APPLICATION NO. 04DRB01882	PROJECT NO. 1003817
PROJECT NAME Broadbent Bus Plc	Tv F-2B-2
EPC APPLICATION NO.	FAX 897-3317
APPLICANT / AGENT <i>Surv-Tek Inc</i>	PHONE NO. 897-3366
ZONE ATLAS PAGE H-15	
(SDP for SUB), (SDP for BP), (FINAL PLATS), (MASTER DEV PLAN), (IR), (AA)	
<b>ONE STOP COMMENT FORM LOG</b>

**DESCRIPTION OF REQUEST:** DIVIDE EXISTING TRACT F-2B-2 INTO 2 (2) NEW TRACTS. GRANT PRIVATE ACCESS EASEMENT AND GRANT PNM EASEMENT. PRELIMINARY AND FINAL PLAT.

TRACTS F-2B-2-A AND F-2B-2-B
BROADBENT BUSINESS PARK
 (BEING A REPLAT OF TRACT F-2B-2, BROADBENT BUSINESS PARK)
 WITHIN
SECTION 9, TOWNSHIP 10 NORTH, RANGE 3 EAST
NEW MEXICO PRINCIPAL MERIDIAN
CITY OF ALBUQUERQUE
BERNALILLO COUNTY, NEW MEXICO
 NOVEMBER, 2004

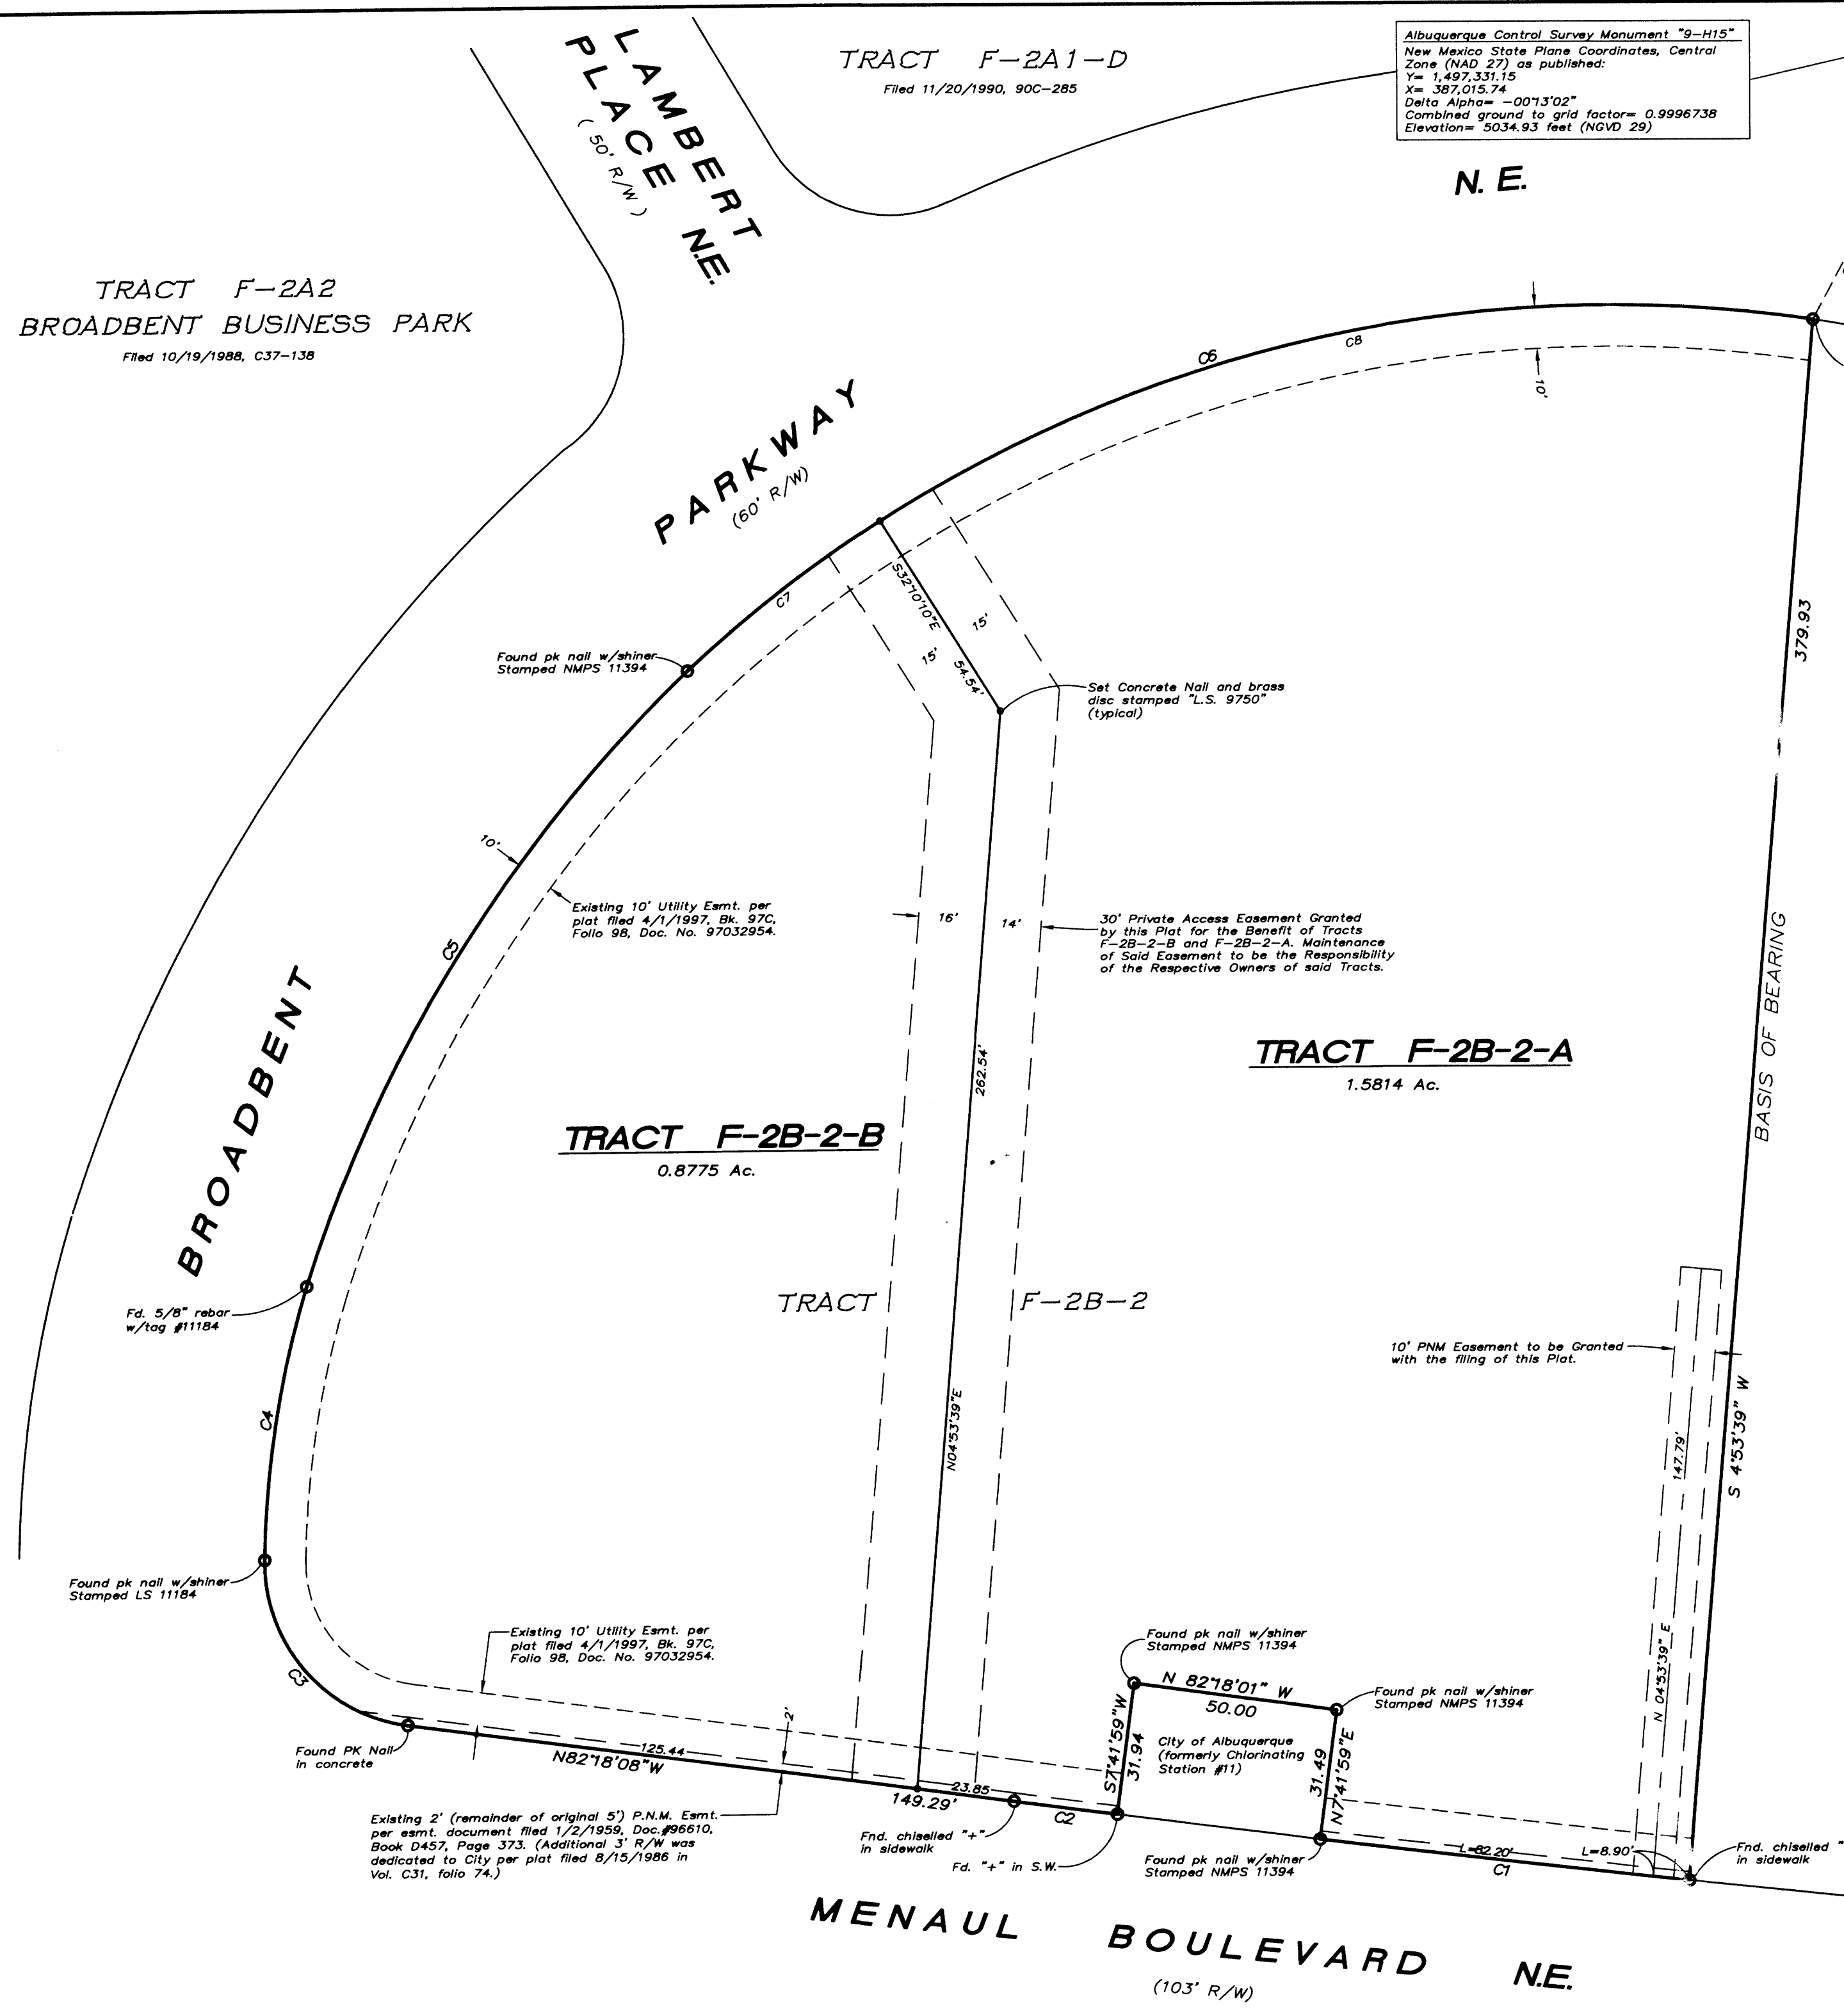
<b>TRANSPORTATION DEV (505) 924-3990</b>		
PLANS DISAPPROVED <b>H/G</b>	DATE <b>12-9-04</b>	DATE
PLANS APPROVED	DATE	DATE
COMMENTS:		
<i>* SIDEWALK R/W DEDICATION</i>		
<i>* WIDEN IS SIDEWALK ALONG BROADBENT?</i>
